Response to Issues – Department of Planning and Environment

21 Honeysuckle Drive, Newcastle – SSD 8019

Landscape Plan | 1:250 @ A1

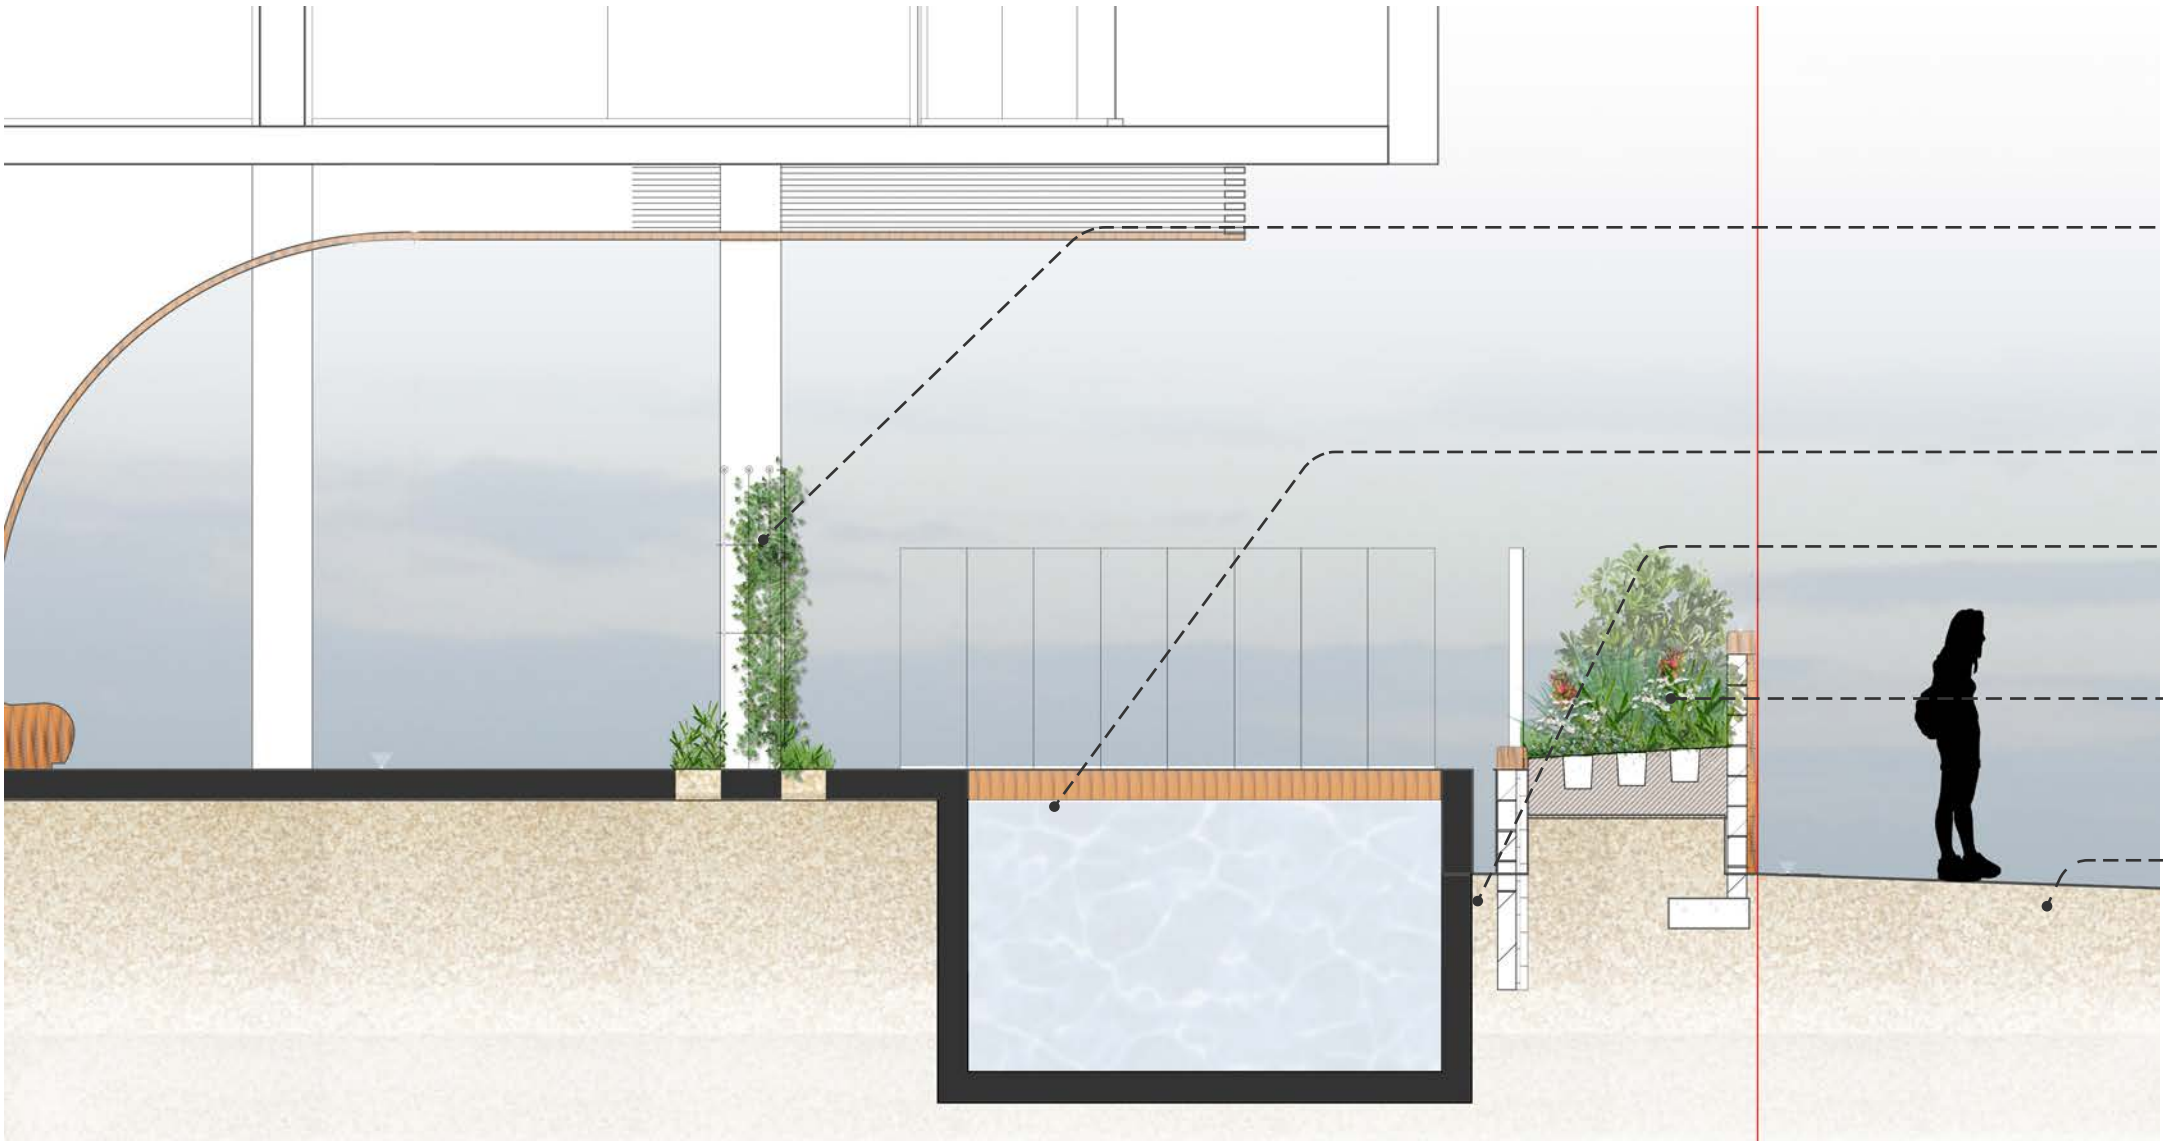
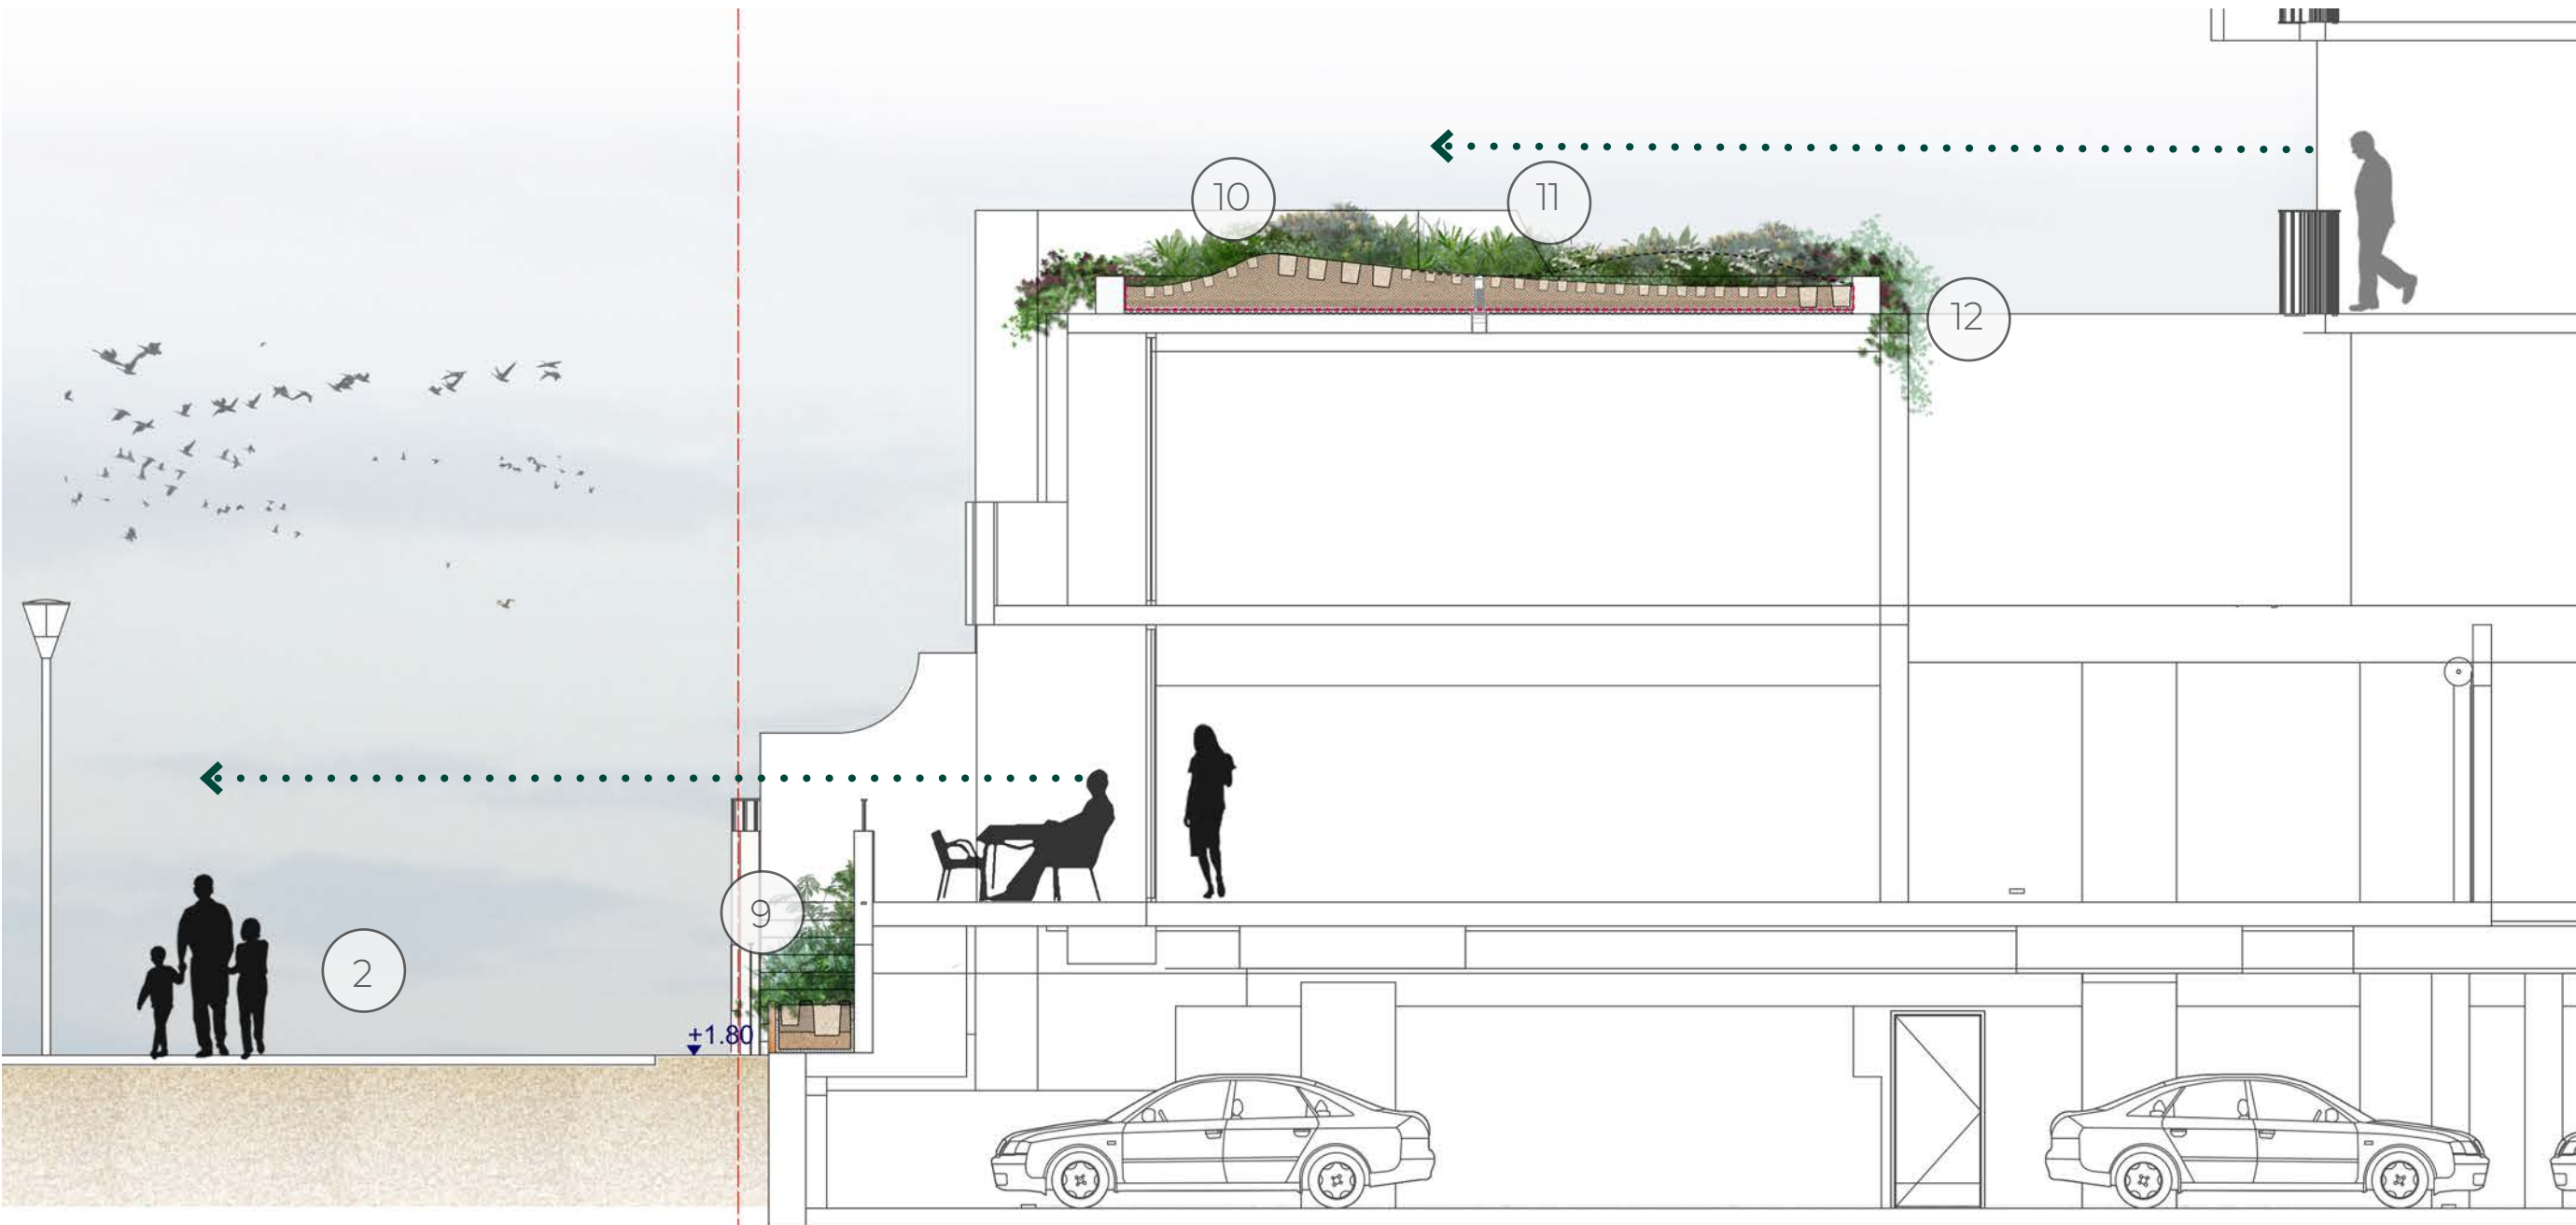
<i>"Further detail of the proposed communal open space is required, including landscaping, seating, bbq's or other facilities to be provided, any lighting, materials and finishes and detail of any privacy screening."</i>	An updated set of Landscape Plans prepared by Sydney Design Collective details communal open space areas at main roof level.	See Attachment 2
<i>"Indicative furniture layouts demonstrating the functionality of the 1 bedroom balconies."</i>	An updated set of Architectural Plans prepared by SJB Architects details furniture layouts to balcony areas.	See Attachment 1
<i>"The views from the sun indicate that the Level 1 apartments A104, A105, B104, B105, C104 and C105, while receiving solar access to private open spaces do not receive sufficient solar access to living areas. It is requested that the glazing to the living room of these apartments be</i>	The revised Architectural package illustrates the repositioned of glazing line to both the northern and southern elevations to those apartments within the central portion of the building to ensure solar access to living areas is achieved. In addition, it is noted that the privacy screen walls of the balconies / terraces to the northern courtyards have been reduced from 2.5m to 2.0m to enable greater solar access.	See Attachments 1 and 5
